Case Officer: Gemma Magnuson

Applicant: Ms Debbie Whitford

Proposal: Removal of roof. Construction of new roof with bedroom accommodation

SOUTH ELEVATION

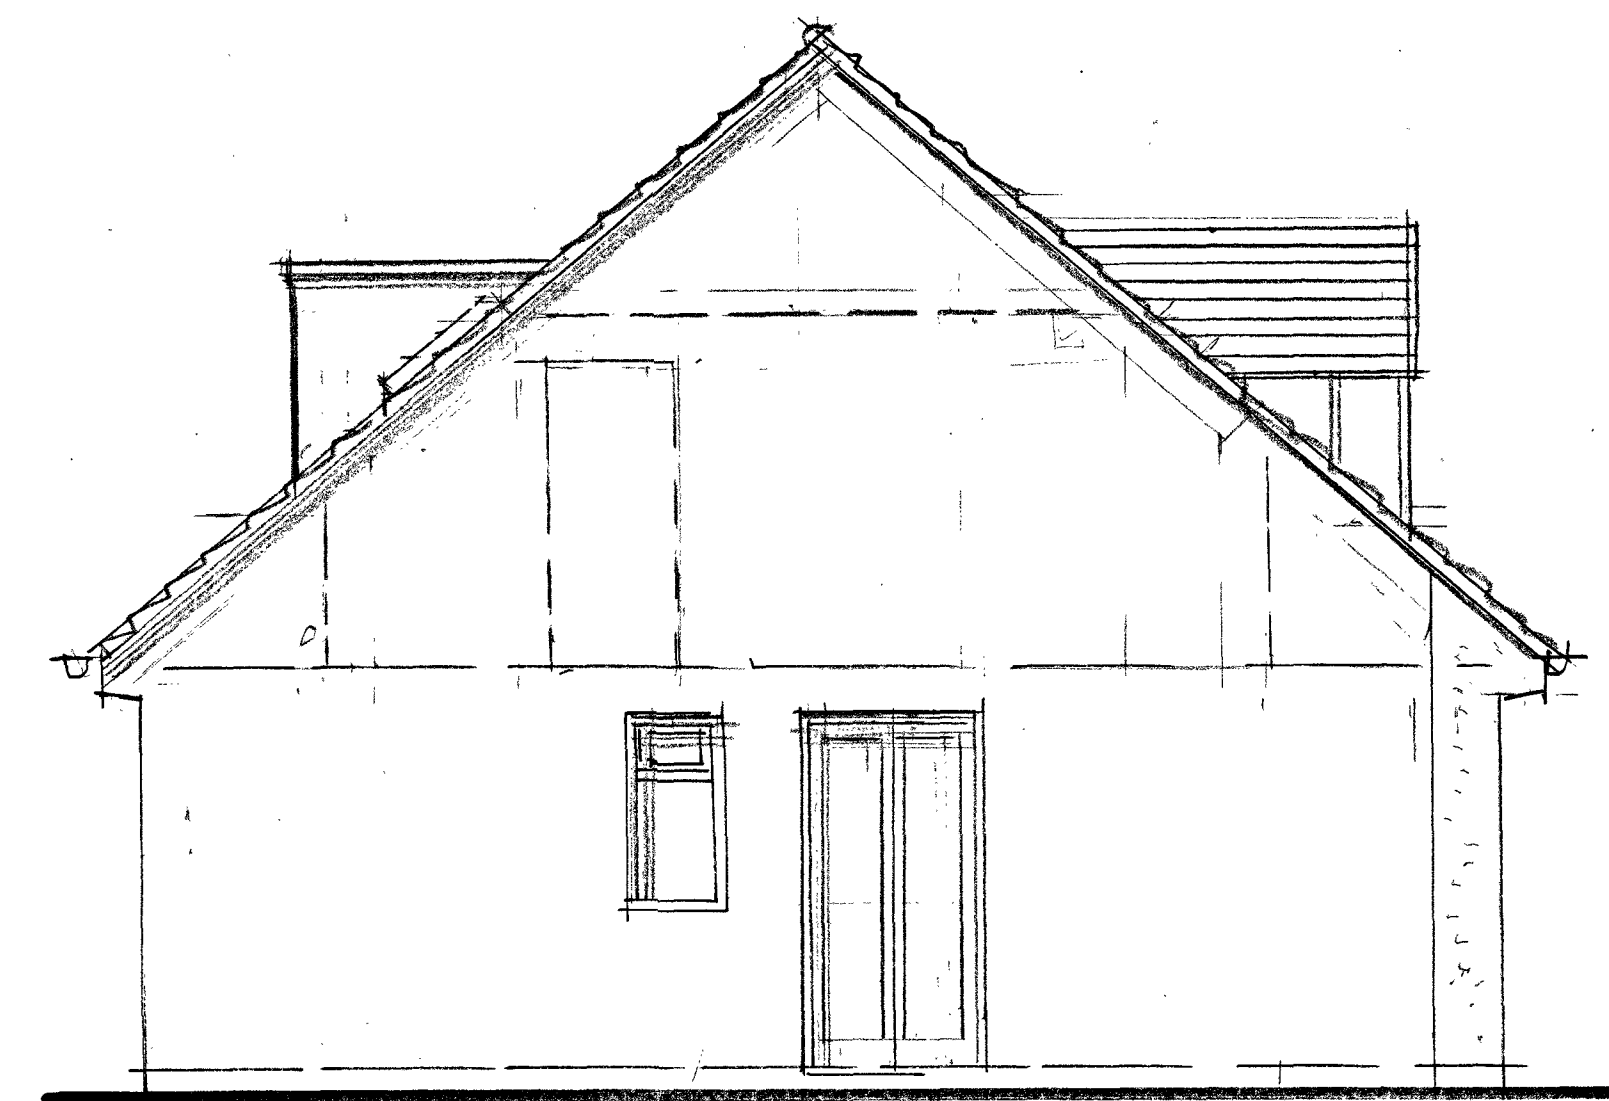
- 8.8. Pitched roofed dormer windows are proposed upon the more visibly prominent frontage, and I consider these to be sympathetically designed, centred over the ground floor openings and not appearing disproportionate to the remaining roofslope.

- 8.9. A flat roofed dormer window is proposed to the rear, which in unfortunate, as it would be visible from the adjacent car park. However, given its small size, I do not consider that it would appear overly prominent or cause harm. The rooflights are not excessive in number, and I do not consider that they would cause harm.

- 8.15. Firstly, The Old Seven Stars to the south-west of the site. Whilst the proposed increase in height and openings would be a sufficient distance from the dwelling itself to avoid harm, the proposed flat roofed dormer window would be positioned in close proximity to the shared boundary to the west, and would be visible above the existing boundary hedge where there are no openings at present.

- 8.16. However, given the small size of the dormer, the proposed use of obscure glazing and that not the entirety of this neighbour's garden would be affected by the perception of overlooking, I do not consider that I can reasonably argue that significant harm would be caused in terms of a loss of privacy for this neighbour. I have recommended that all openings on this elevation are obscure glazed in order to avoid any overlooking of the neighbour, with any opening parts above 1.7 metres from floor level.

4. The rooflights and bathroom window on the western facing elevation shall be obscure glazed (Level 3 or above) and fixed shut, unless the cill height of any opening parts are 1.7 metres above the floor of the room within which it is installed.

6. Notwithstanding the provisions of Classes A, B and C of Part 1, Schedule 2 of the Town and Country Planning (General Permitted Development) (England) Order 2015 and its subsequent amendments, no new window(s) or other openings, other than those shown on the approved plans, shall be inserted in the roof of the western facing elevation without the prior express planning consent of the Local Planning Authority.
